### Solace of Colorado Springs, PPR-20-47

Please accept the following comments from El Paso County Public Health regarding the project referenced above:

**SOLACE AT CIMARRON HILLS**  
— FILING NO. 1  
POND B PLAN & CROSS SECTIONS

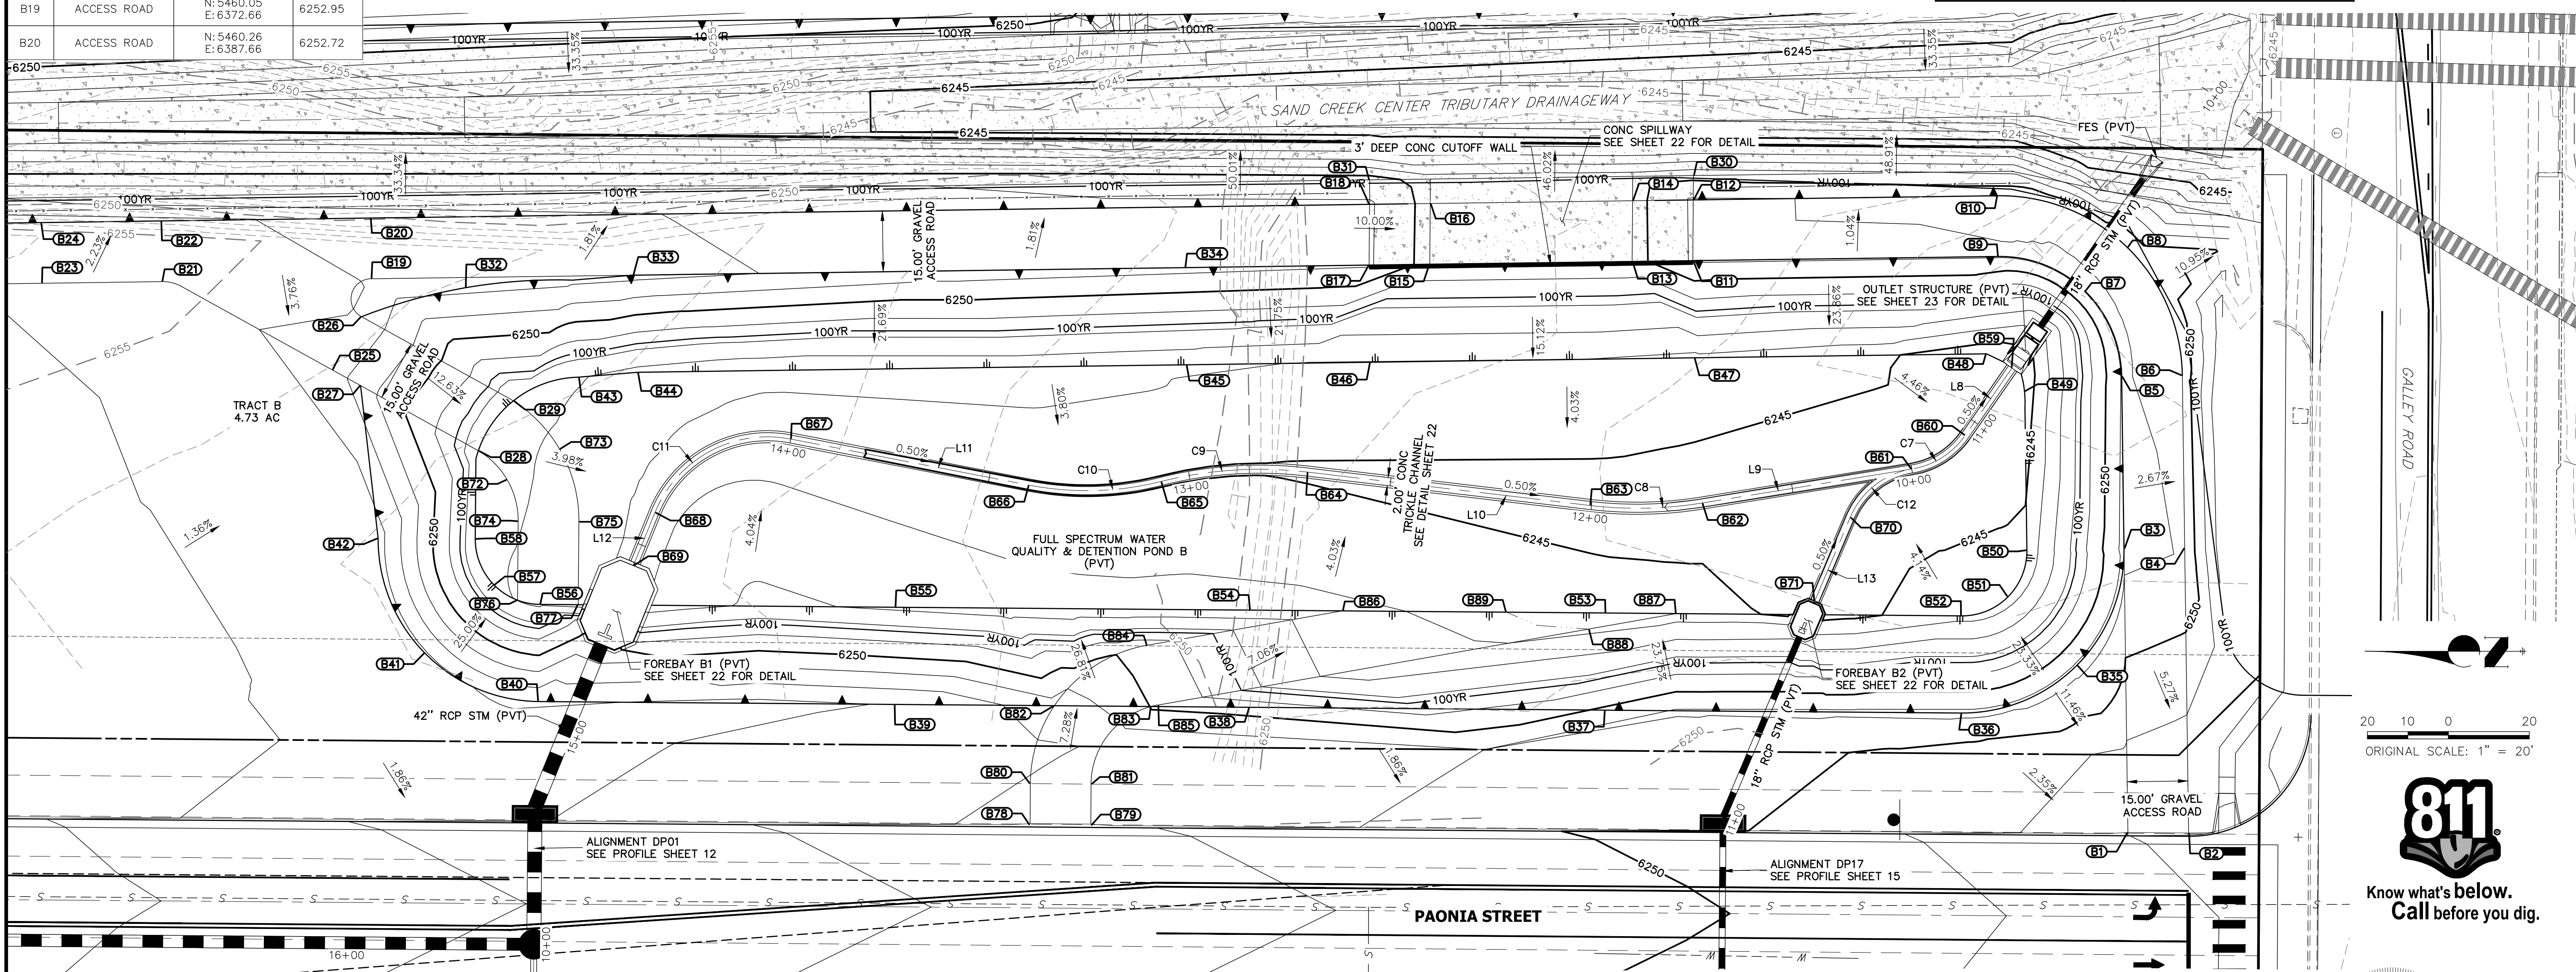
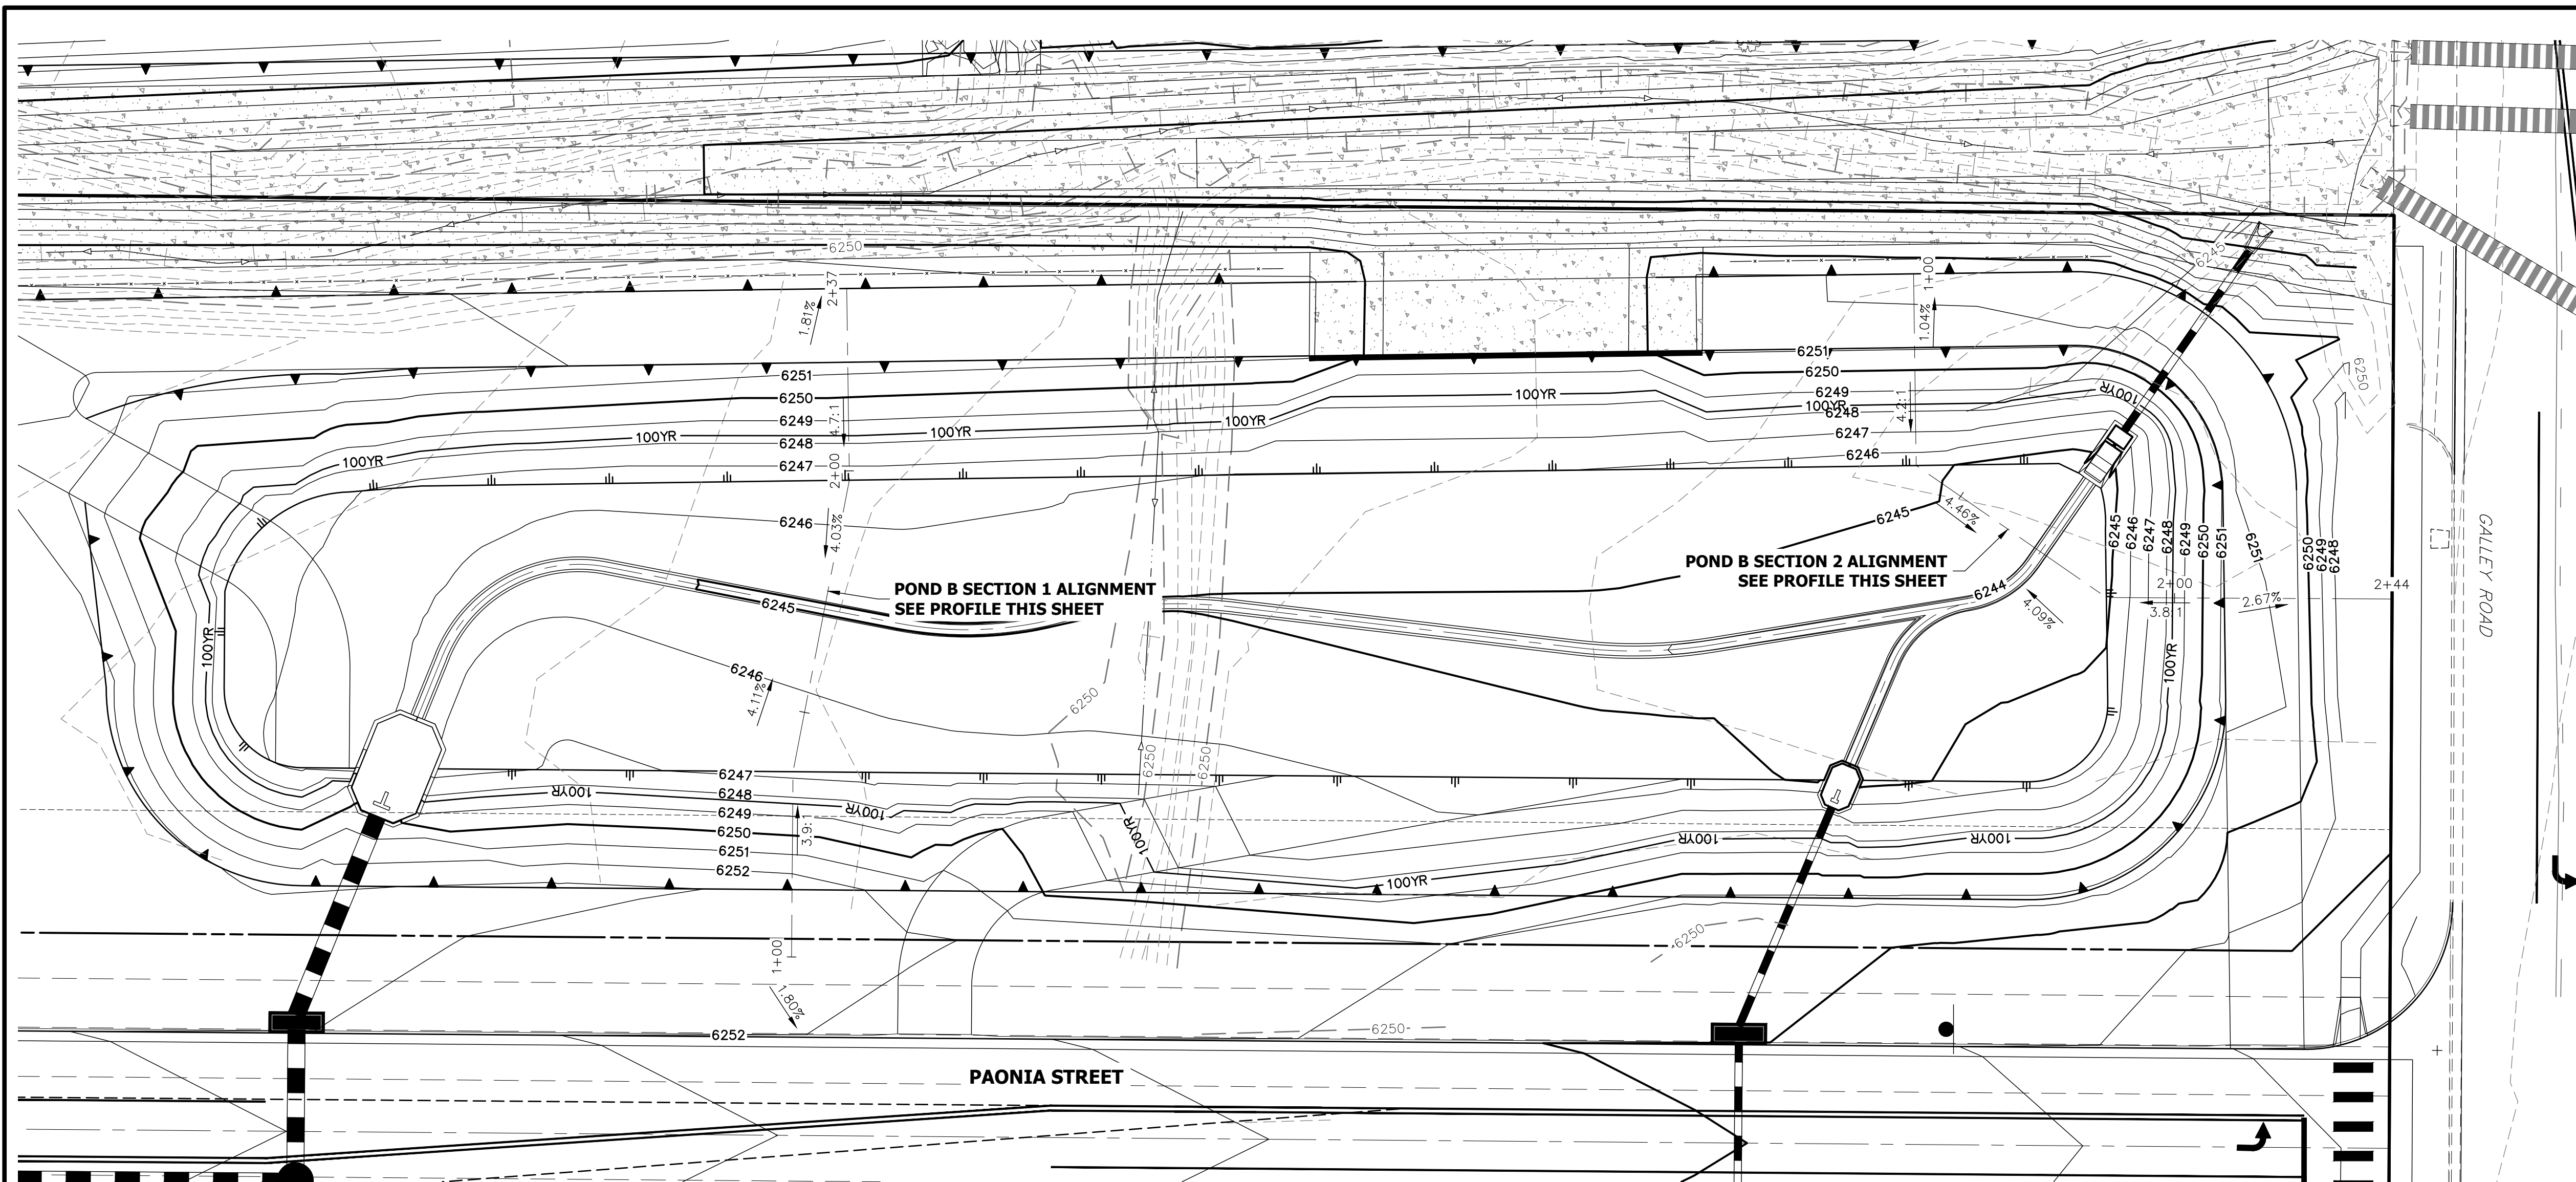
- The two water quality basins must have mosquito control responsibilities included as a part of the construction design and maintenance plan to help control mosquito breeding habitat and minimize the potential for West Nile Virus.
